Development Review Checklist

Level I / **Level II** / Level III / Master Plan
 Project Name: Luminato
 Address: 169 Newbury Street
 Description: Alteration / Addition / **New Construction**
 Date Received: 03/08/16 Prelim / **Final**
 Planner: Caitlin Cameron

Complies	More Info	Does Not Comply	N/A	Comments
BUILDING DESIGN STANDARDS (BDS)					Review (3/14/16) Caitlin Cameron, Rick Knowland, Jean Fraser Comment: 3 rd Floor Plan missing

2 | EAST ELEVATION
 1/8" = 1'-0"
 0 2'-0" 4'-0" 8'-0" 16'-0"

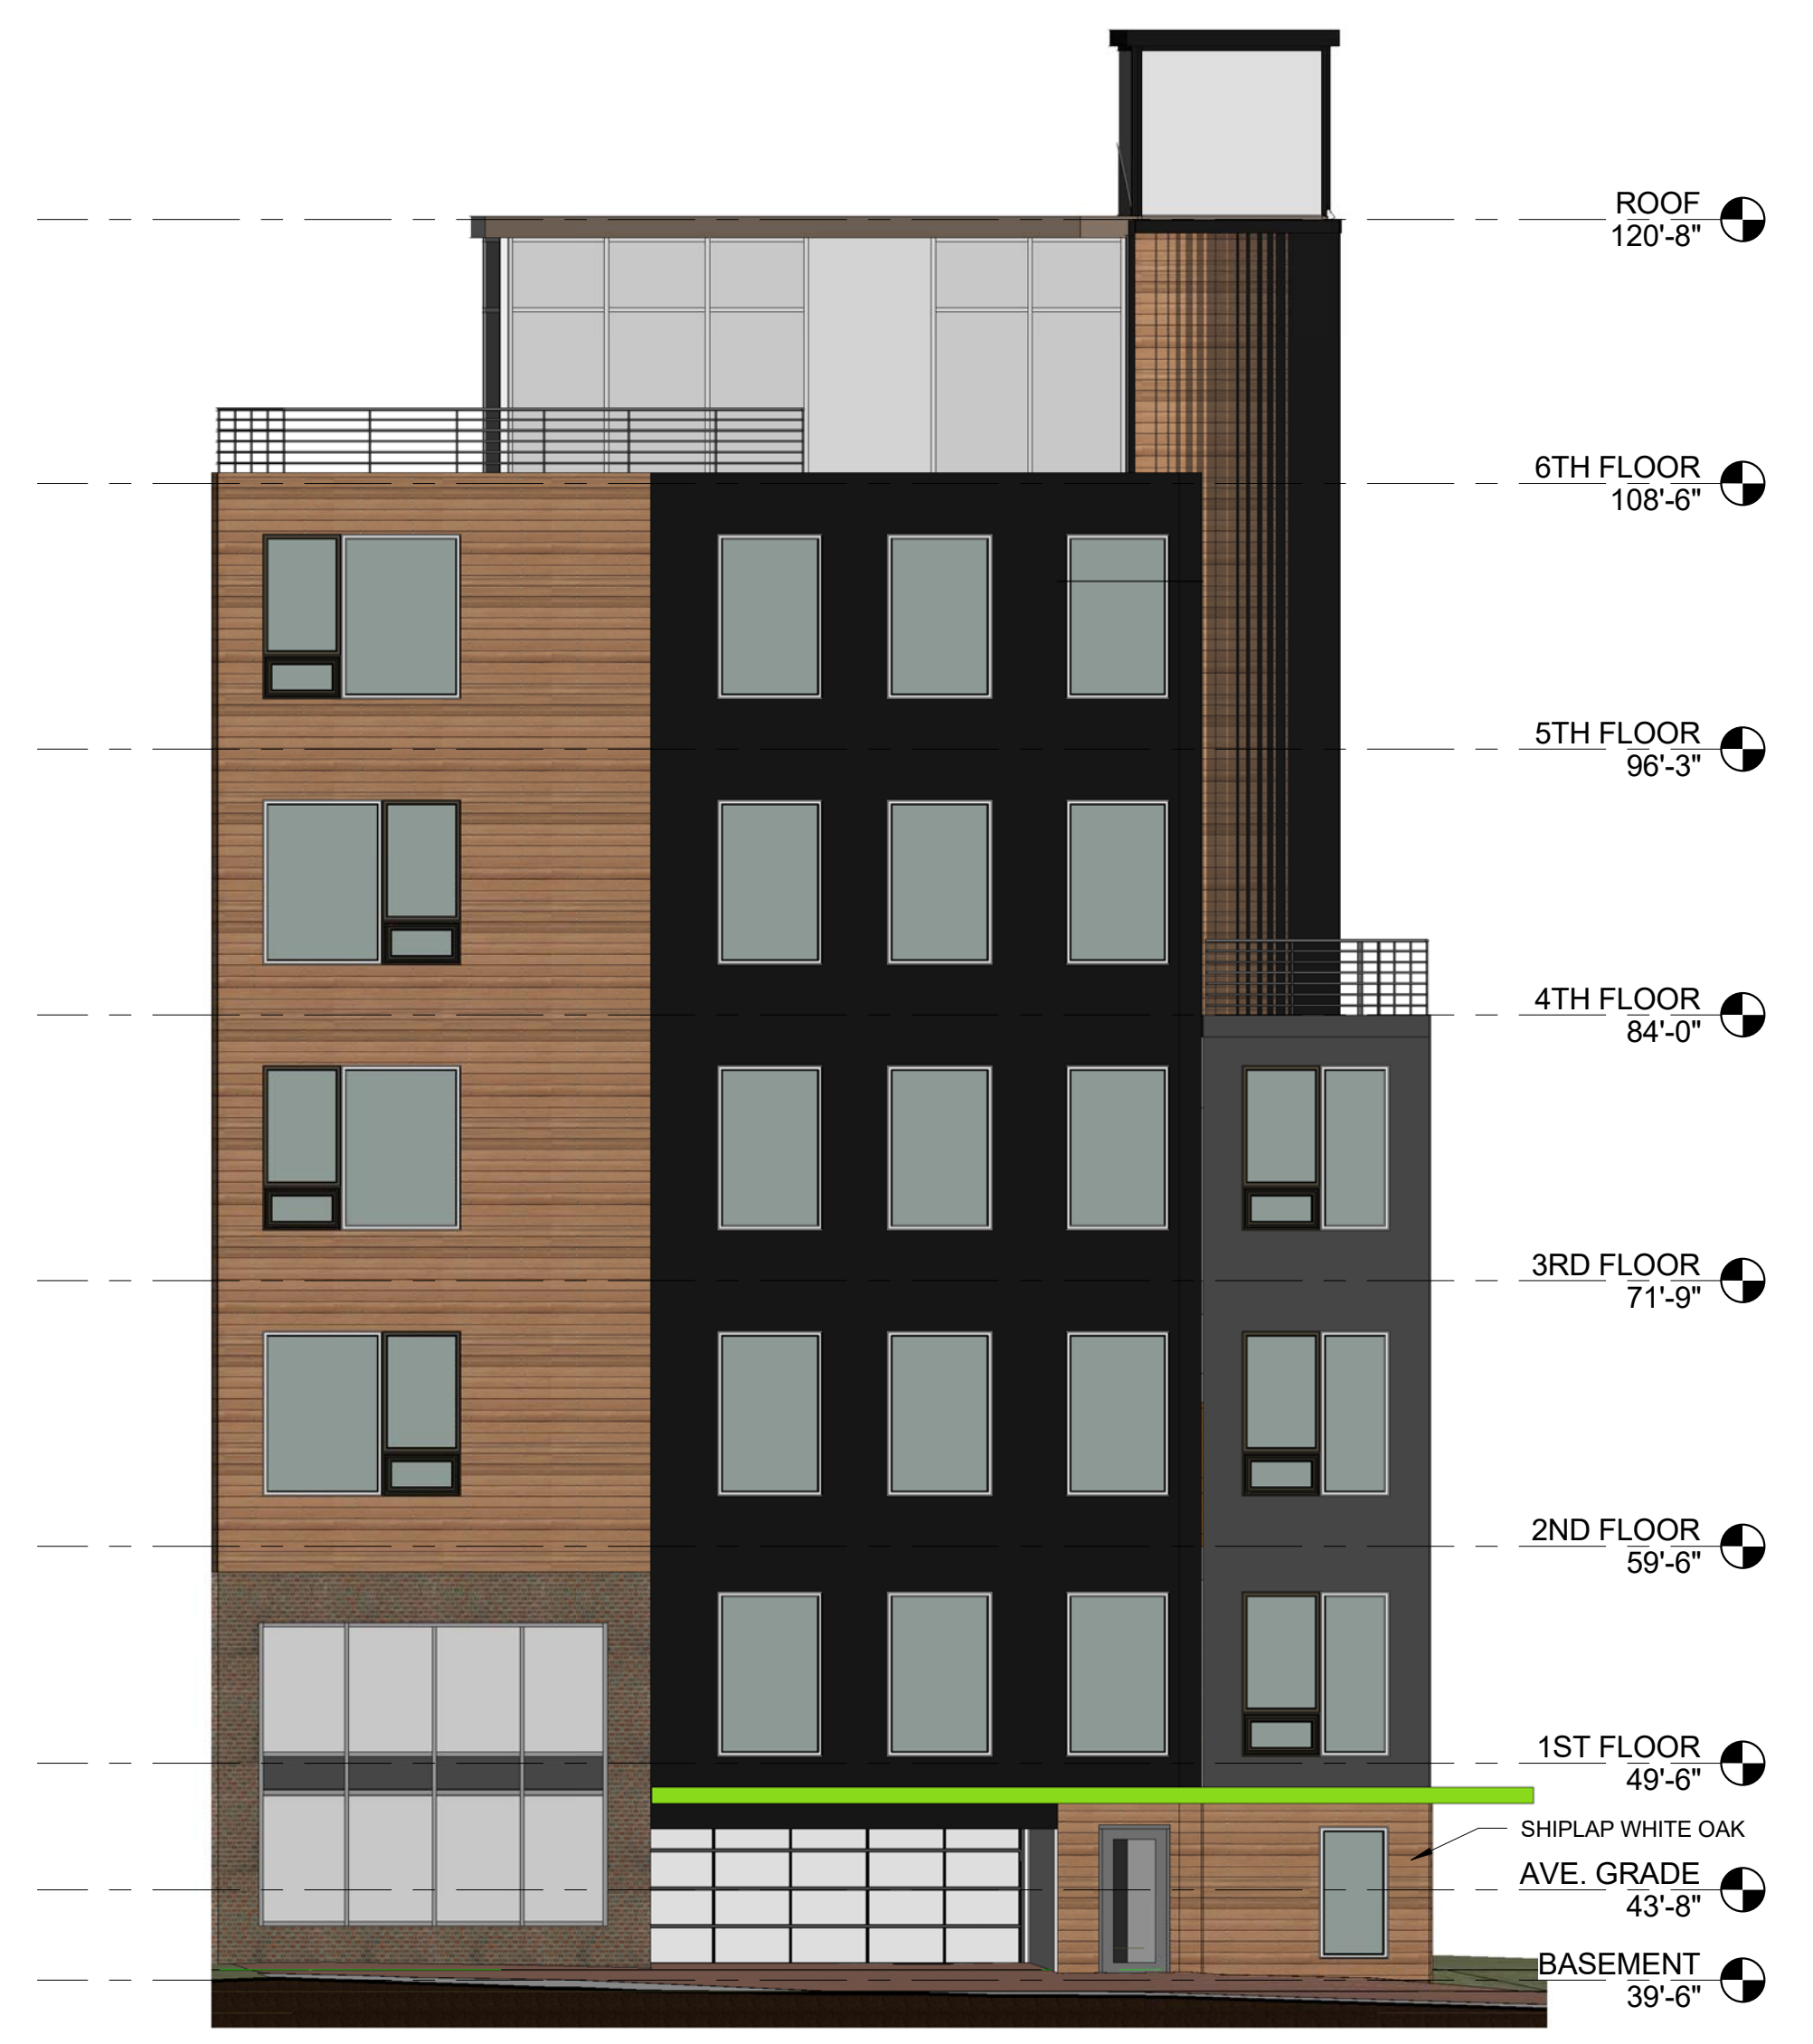
4. Fenestration					
Intent	<input checked="" type="checkbox"/>	<input checked="" type="checkbox"/>	<input type="checkbox"/>	<input type="checkbox"/>	East Elevation does not match floor plans.
Guidelines	<input checked="" type="checkbox"/>	<input type="checkbox"/>	<input type="checkbox"/>	<input type="checkbox"/>	
Standard 4.1 (UA only)	<input type="checkbox"/>	<input type="checkbox"/>	<input type="checkbox"/>	<input checked="" type="checkbox"/>	
Standard 4.2	<input checked="" type="checkbox"/>	<input type="checkbox"/>	<input type="checkbox"/>	<input type="checkbox"/>	
Standard 4.3	<input checked="" type="checkbox"/>	<input type="checkbox"/>	<input type="checkbox"/>	<input type="checkbox"/>	No tinting
Standard 4.4	<input checked="" type="checkbox"/>	<input type="checkbox"/>	<input type="checkbox"/>	<input type="checkbox"/>	No spandrel glass

⇒ GREEN ROOF
HEIGHT BONUS

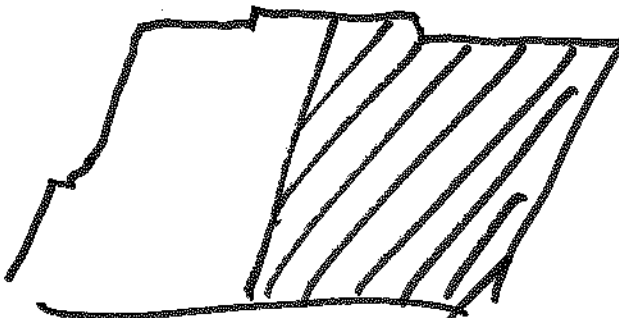
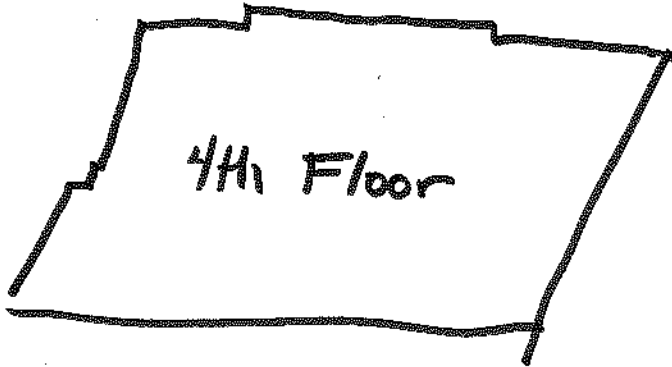
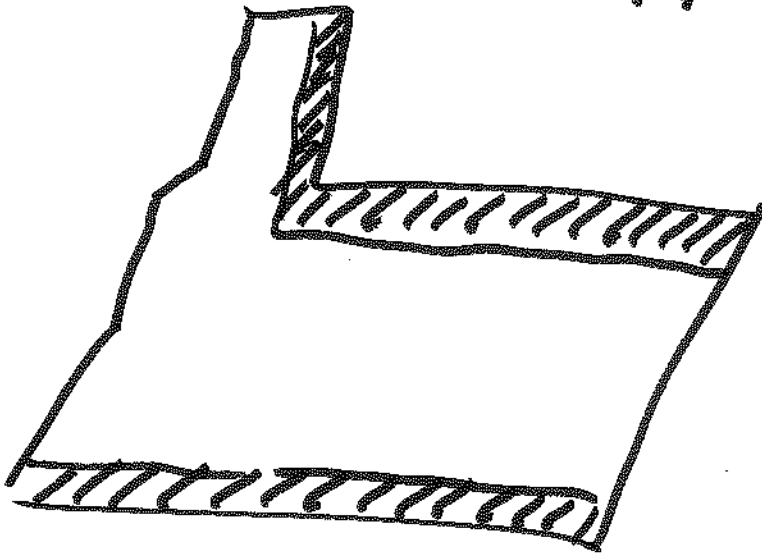
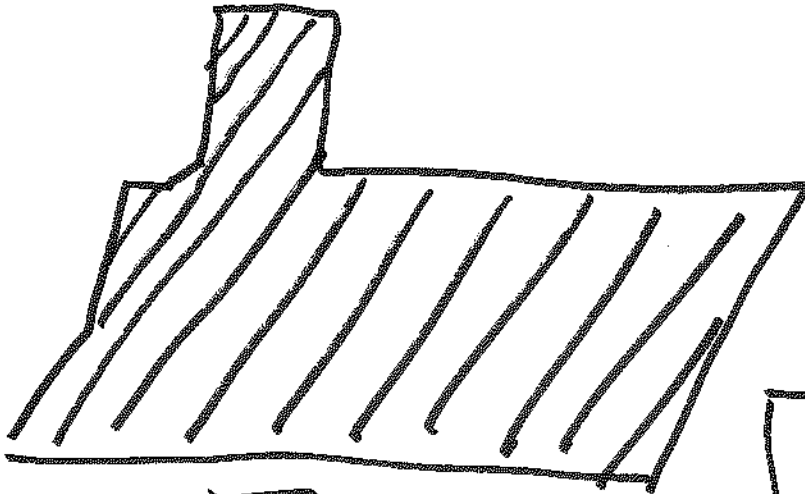
Complies	More Info	Does Not Comply	N/A	Comments
(c) Height Standards					
Height Bonus - Eligible?	<input checked="" type="checkbox"/>	<input type="checkbox"/>	<input type="checkbox"/>	<input type="checkbox"/>	UT are eligible streets
Height Bonus – Conditions Green Roof+Pervious = 5,135sf 50% roof = 3,368sf	<input checked="" type="checkbox"/>	<input type="checkbox"/>	<input type="checkbox"/>	<input type="checkbox"/>	5,135 sf pervious provided on lot. 3,874 sf of green roof provided.
